BUILDING CODE OF AUSTRALIA ASSESSMENT REPORT

Project: Block 1&4N
20-102 Broadway, Sydney

Client: Frasers Broadway
Report: RE142467 Issue 1 draft
Date: 19 June 2014

01 Cladding Type D - Typical Bedroom Slot Facade - Section
1:20

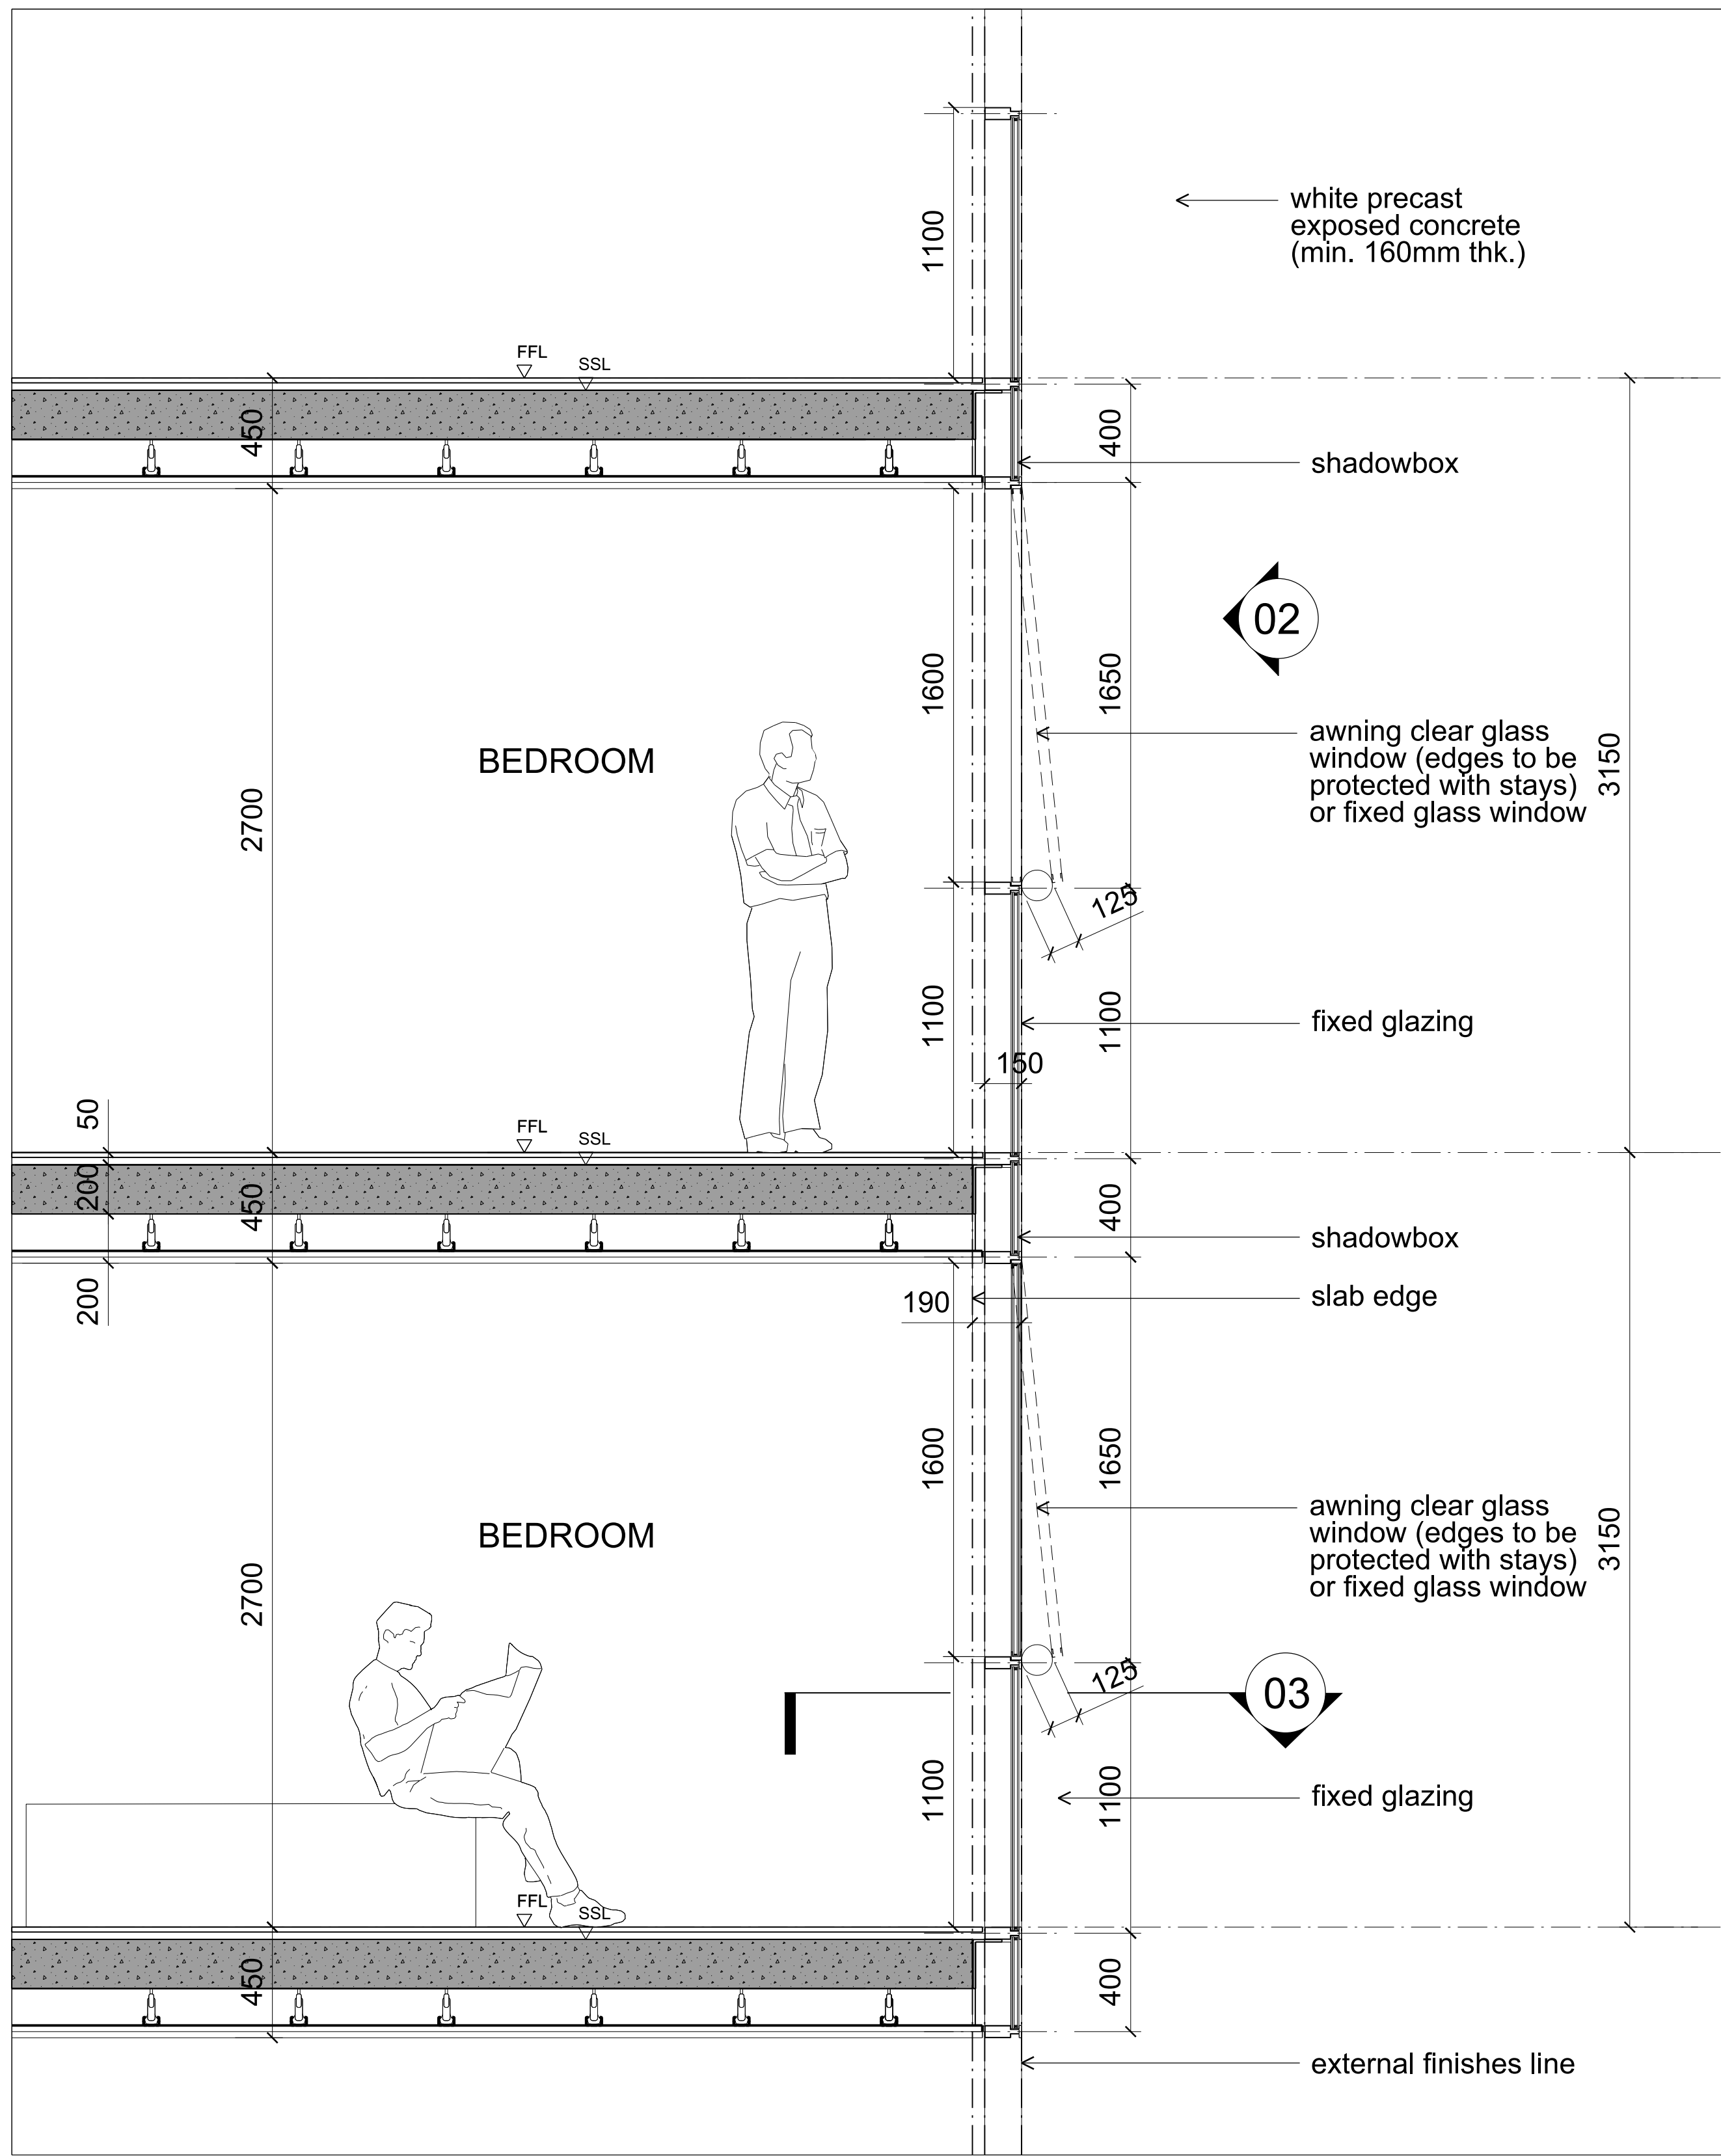
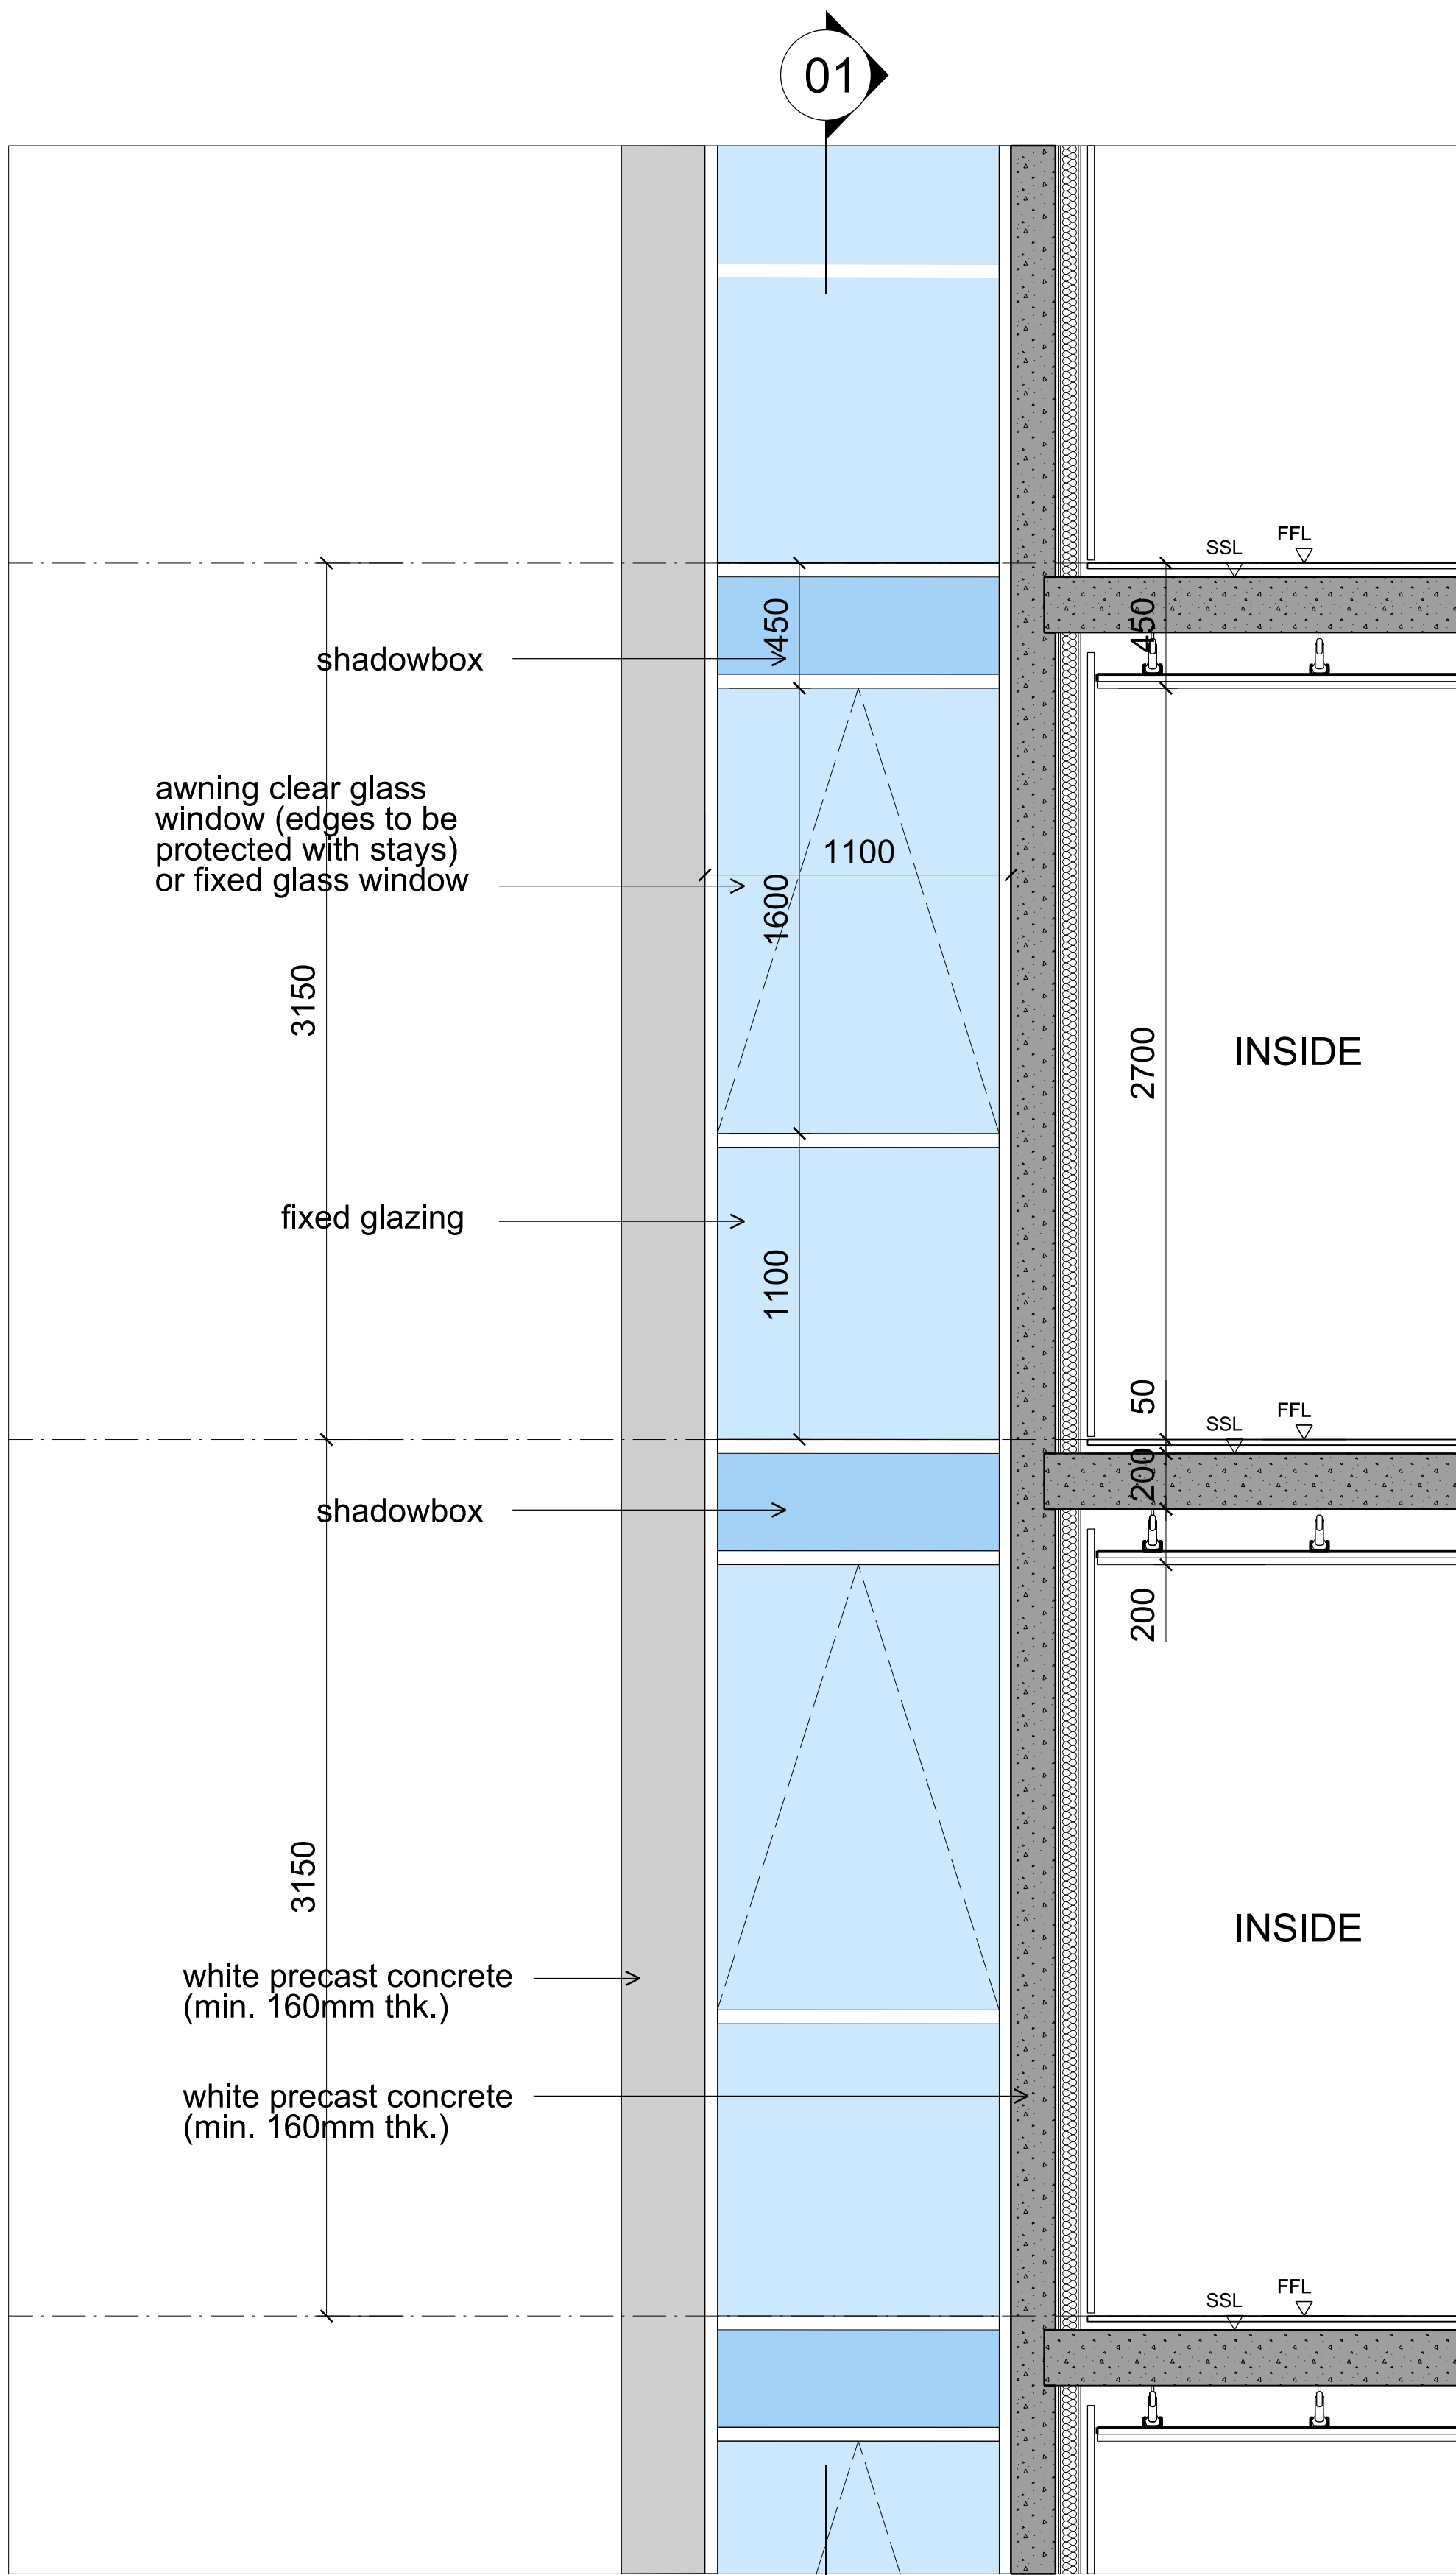
E2.2 Zone smoke control	The loading dock and retail tenancies are not proposed to contain zone smoke control.
F4.1 Natural light	The study rooms on Level 04 to 17 bounding the west slot rely on natural light via the slop which does not comply with F4.2(b).
